**Kirtlington Post Office Stores 1 Troy Lane
Kirtlington OX5 3HA**

19/02888/F

Proposal: Change of Use of Shop to Residential, alternations to front window and two new roof lights.

West Elevation (Front) As Proposed
1:100@A1

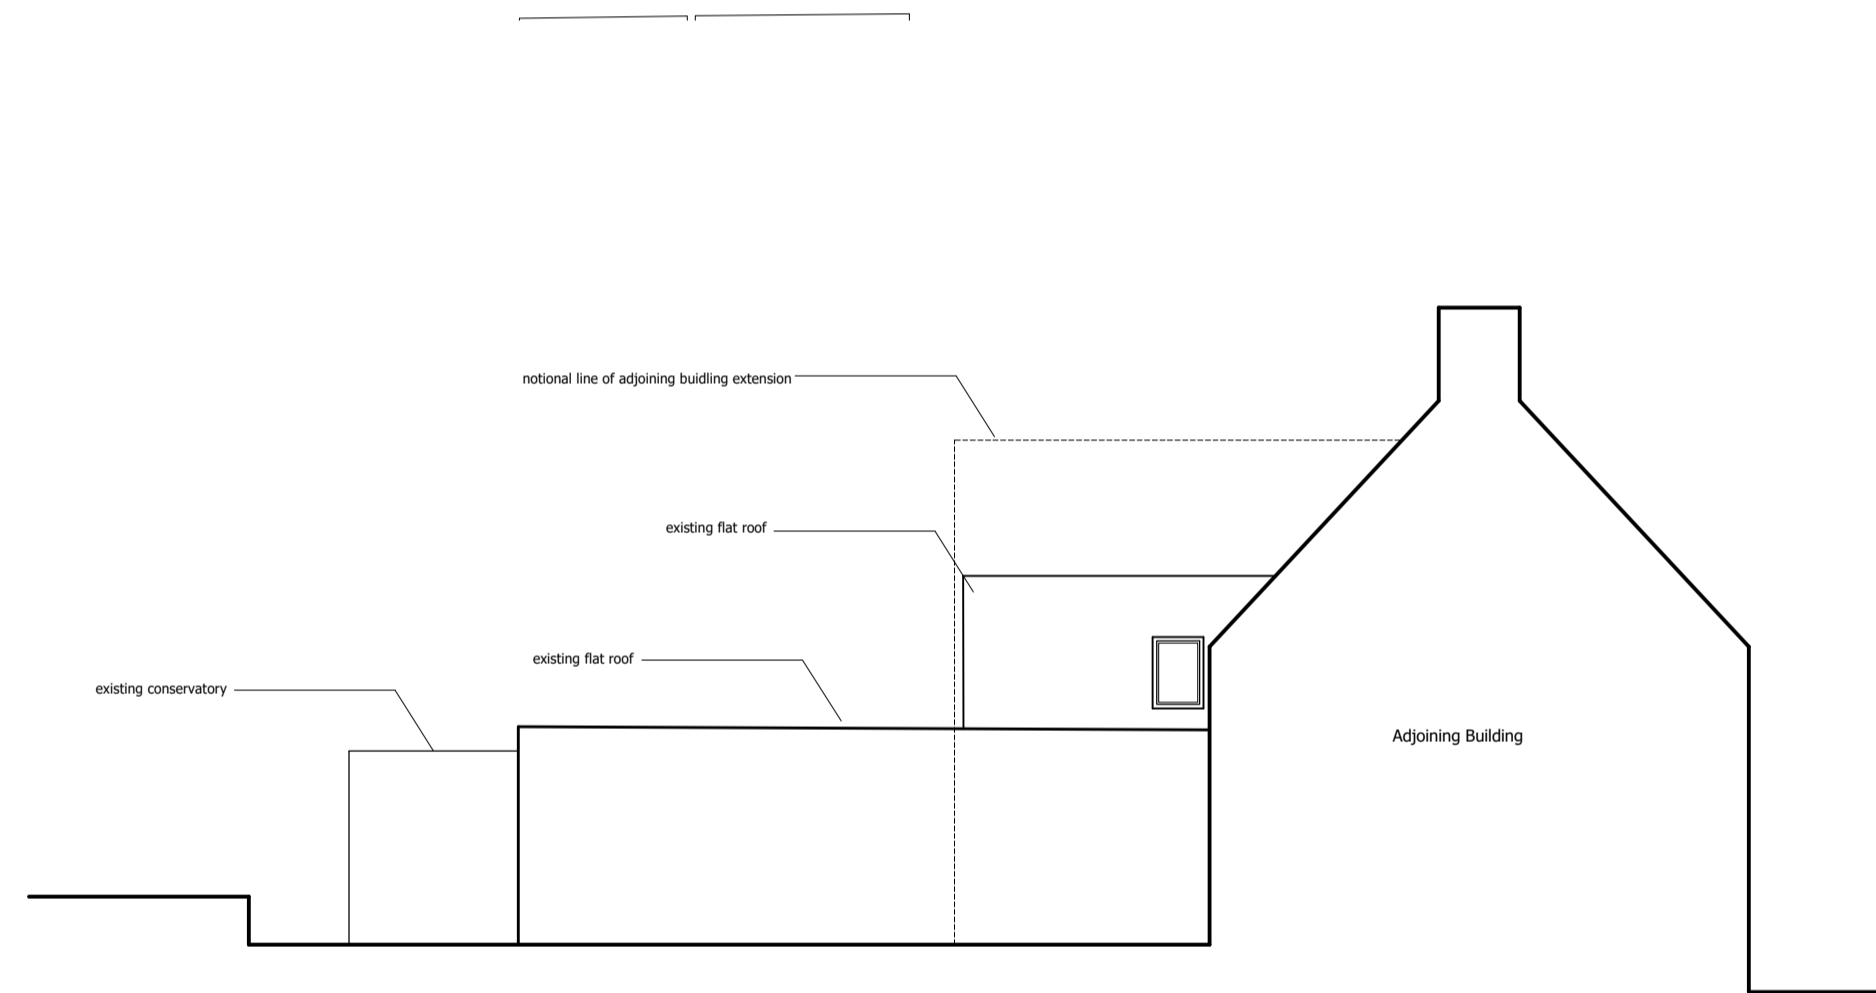
- 8.10. The proposed alterations to the front elevation are considered to be acceptable and the proposed window would match the size and form of the existing ground floor window in this elevation giving a consistent appearance to the building.

East Elevation (Rear) As Proposed
1:100@A1

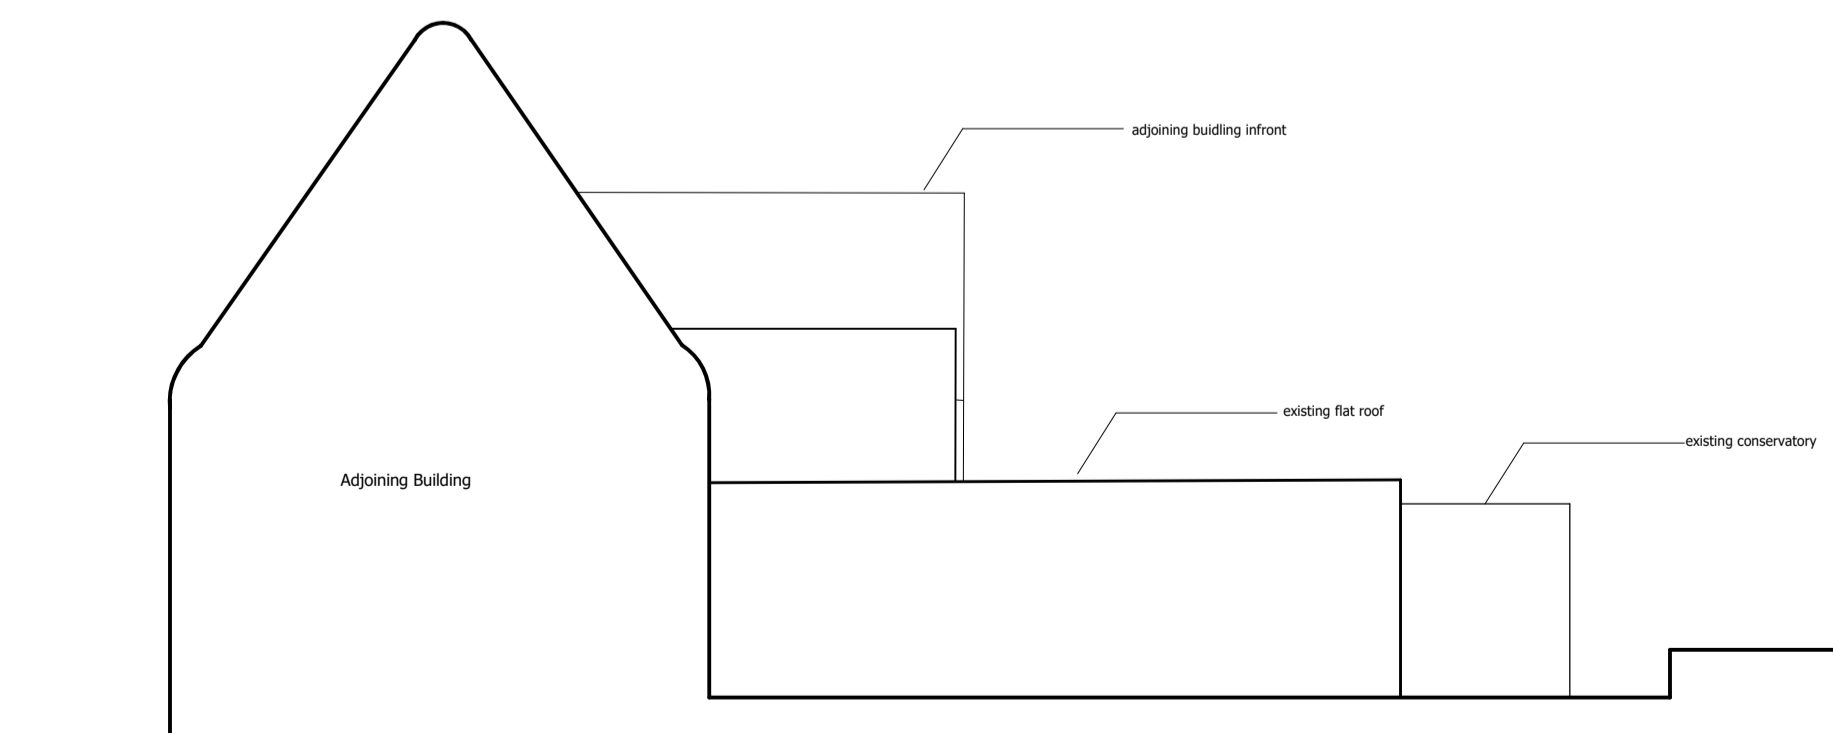
- 8.11. The rooflights require planning permission as the property does not currently benefit from permitted development for rooflights. The rooflights in the rear elevation would not be readily visible in public views due to the relationship with surrounding buildings and by reason of their siting would not result in any significant detriment to the visual amenities of the area.
